TfNSW Reference: SYD20/00506/05

DPIE Reference: SSD-10457

**ADDITIONAL INFORMATION AND UPDATED SIDRA FILES EASTERN CREEK
RETAIL OUTLET CENTRE - LOT 3 ROOTY HILLS ROAD, EASTERN CREEK**

SCALE: 1:250@A1

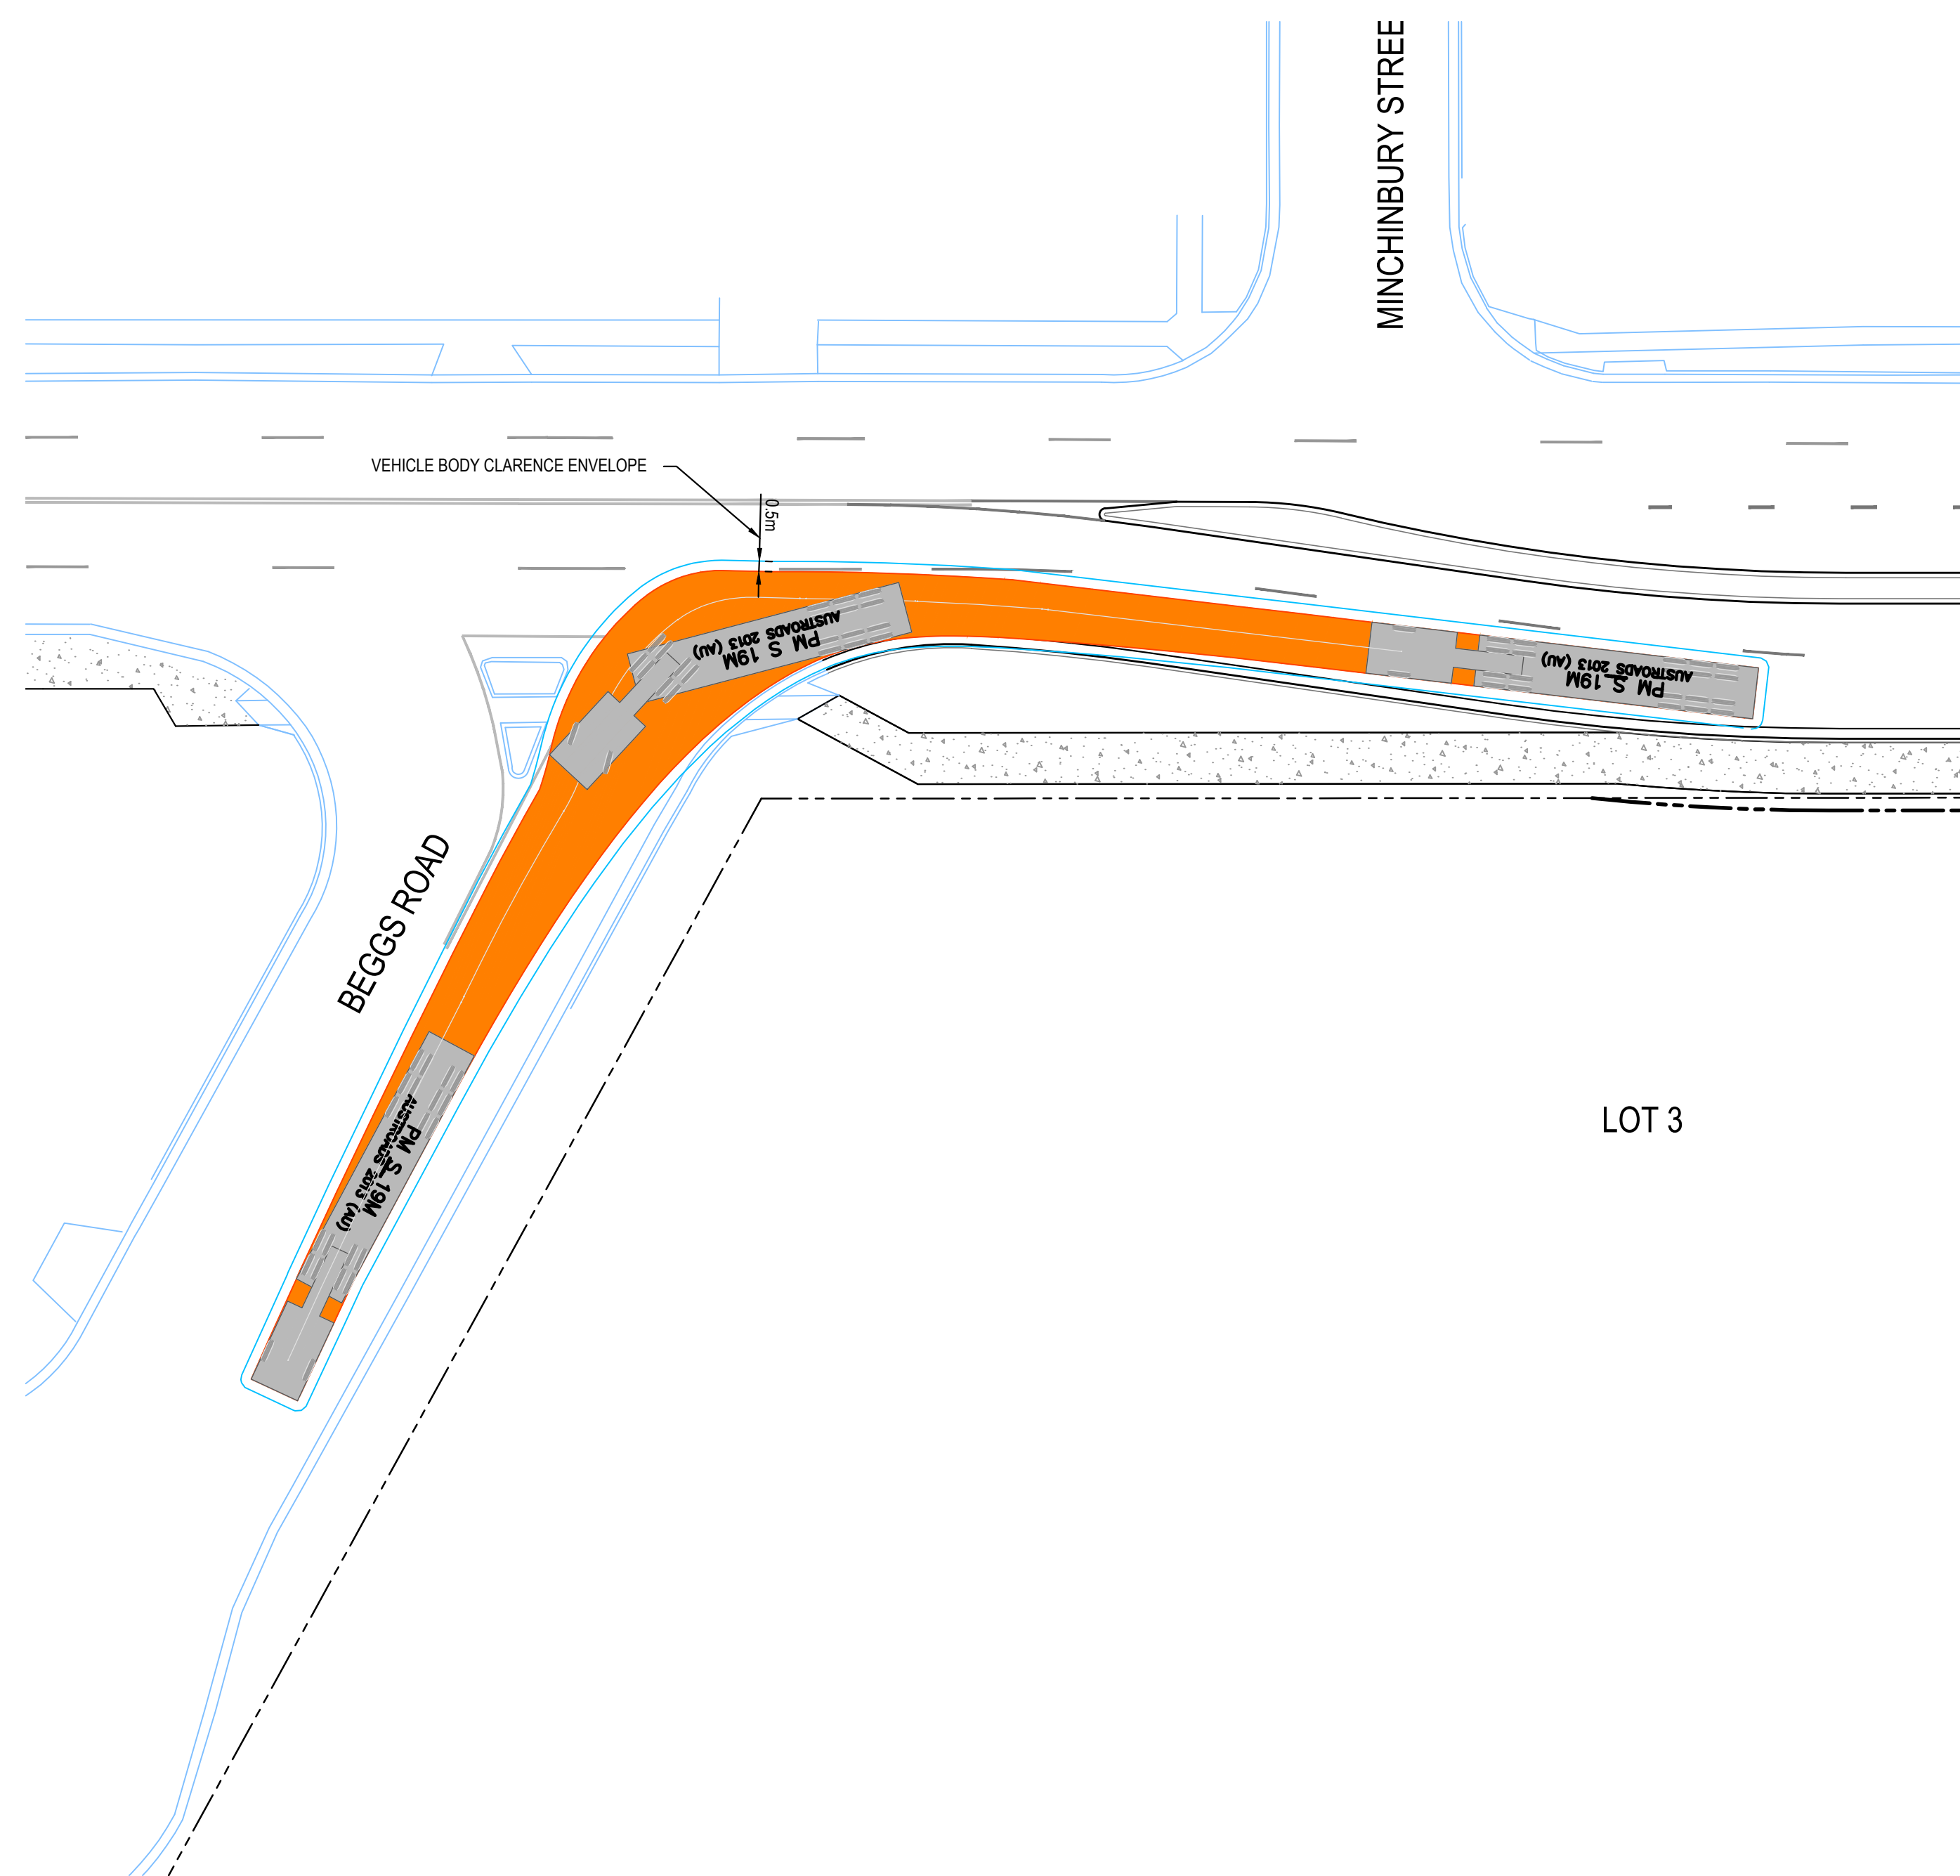
10. Concept civil design plans, swept paths and a draft Traffic Control Signal (TCS) plan of the proposed Rooty Hill Road South /Church Street intersection need to be submitted to TfNSW for review and approval.
